**RE: Paseo del Norte Sports Complex, Tract A, Loop Industrial Park
Grading and Drainage Plan
Engineer's Stamp Date 5-20-2015 (File: C17-D008)**

Based upon the information provided in your submittal received 5-12-15, the above referenced plan can be approved for a building permit until the following comments are addressed:

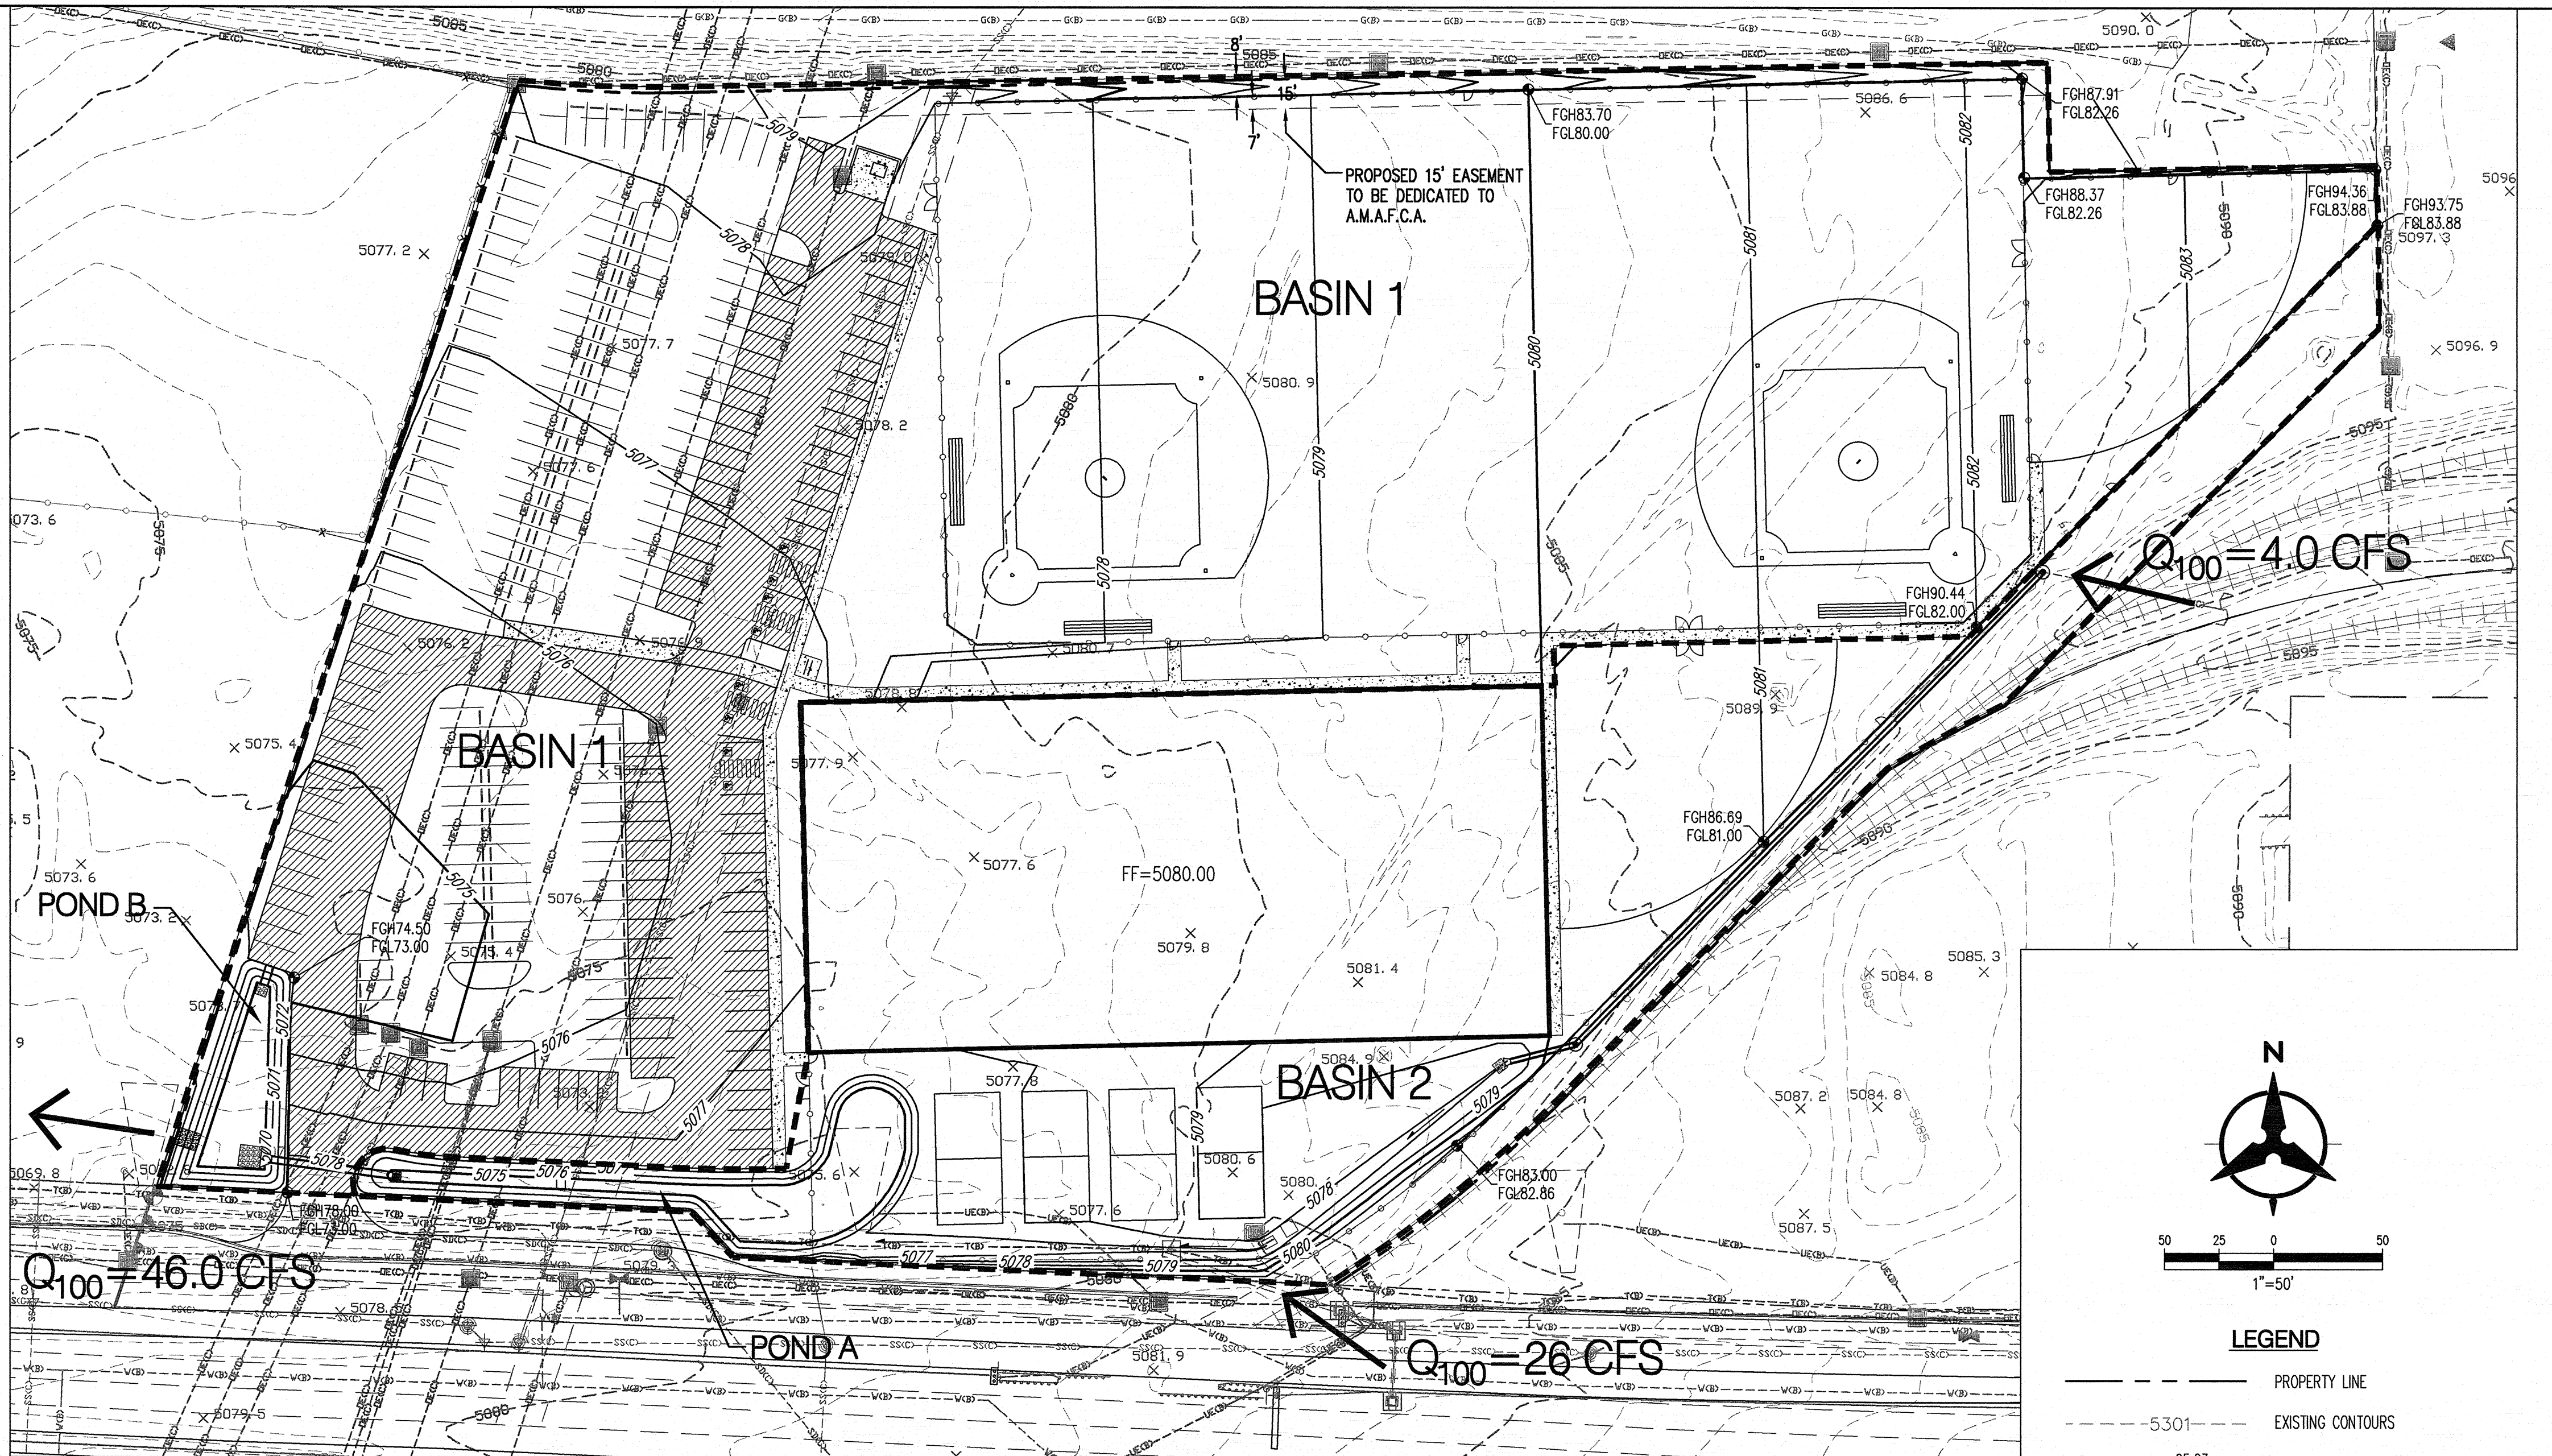
- 2) Make sure that the water surface elevation within the AHYMO run matches what is shown on Sheet C-001, and also provide the required and provided storage volumes along with the WSEL information. (There is a minor discrepancy of 77.28 in the AHYMO versus 77.41 on the plans for Pond "A".)

date
6-10-15
sheet
c100

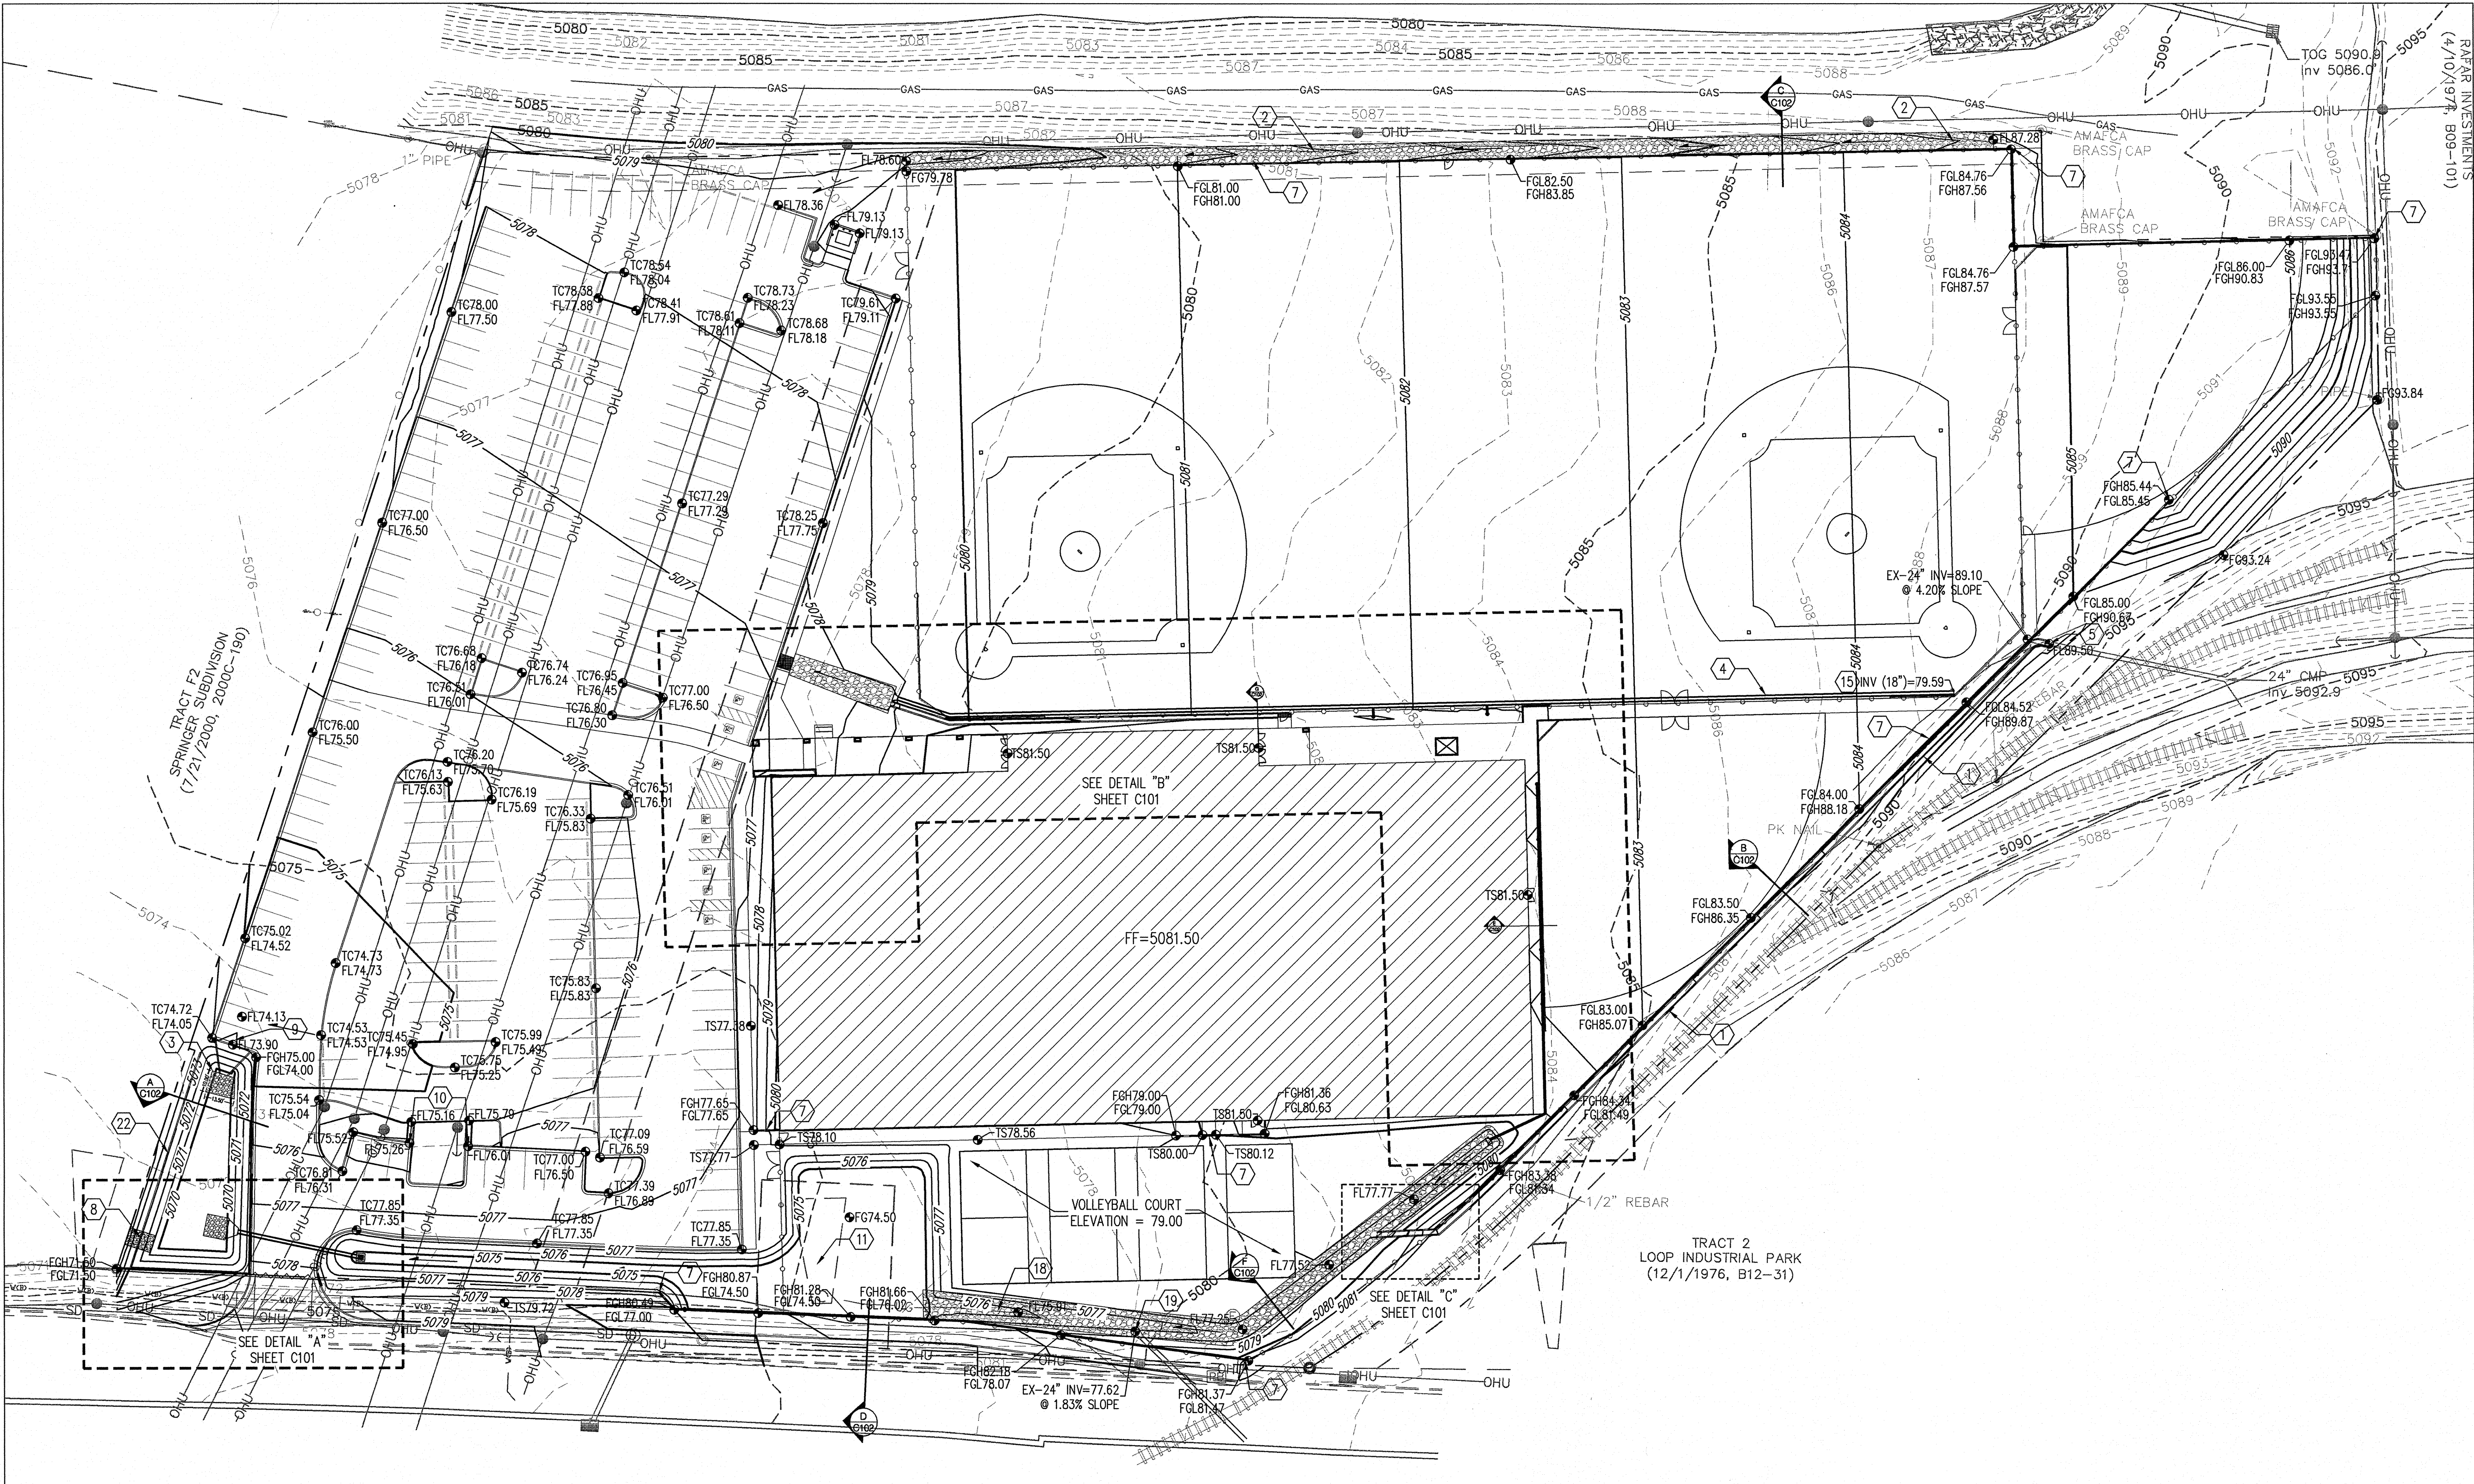
- 3) On Sheet C-100, show more spot elevations and a "top of pond boundary" defining the top of the Pond "A" if it is at an elevation of 77.85. It is not clear that the top of the pond is set at this top elevation within the grading plan itself. Provide similar information for the other pond.

P 16' RUNDOWN DETAIL
N.T.S.

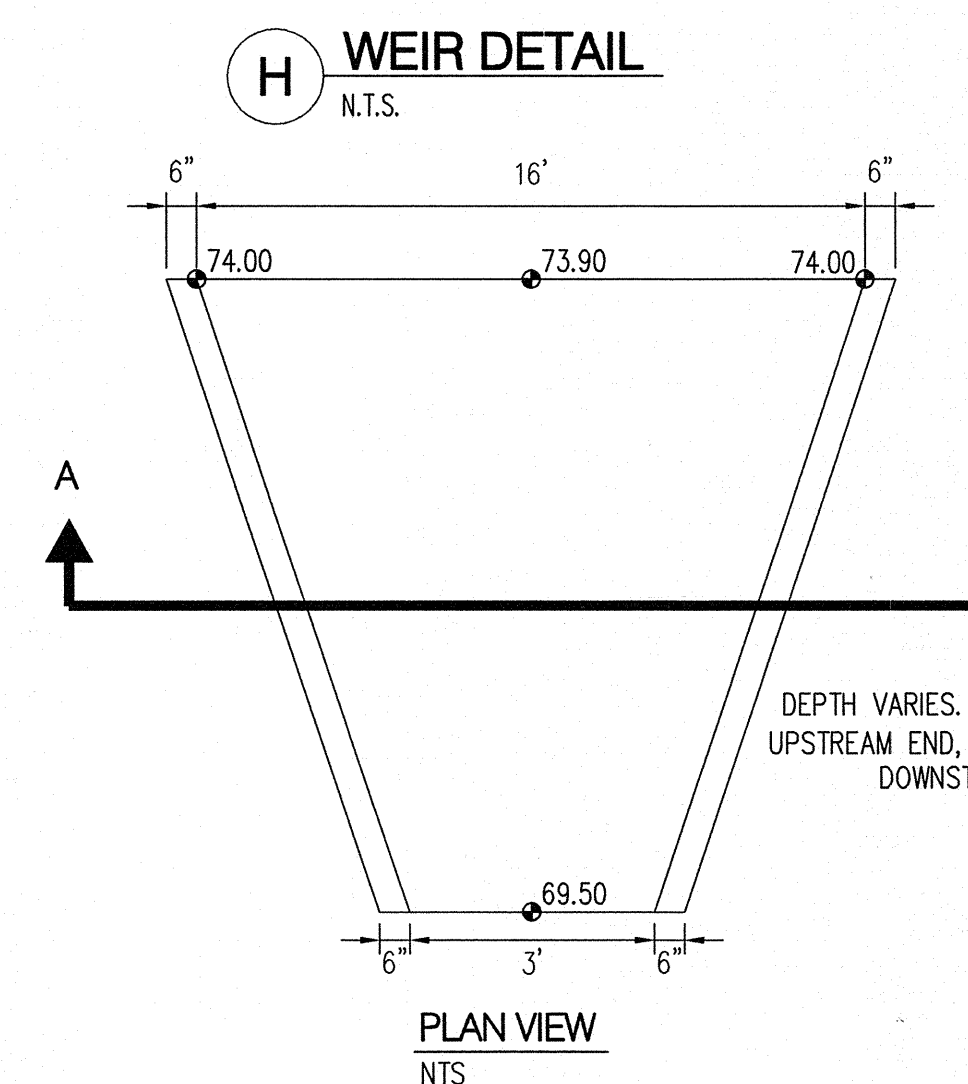
7) Provide concrete rundown details for rundowns R1 and R2. Also, make reference to them on Sheet C-001 by the same designation. (You have them called out as "RD-1", "RD-2", etc.)
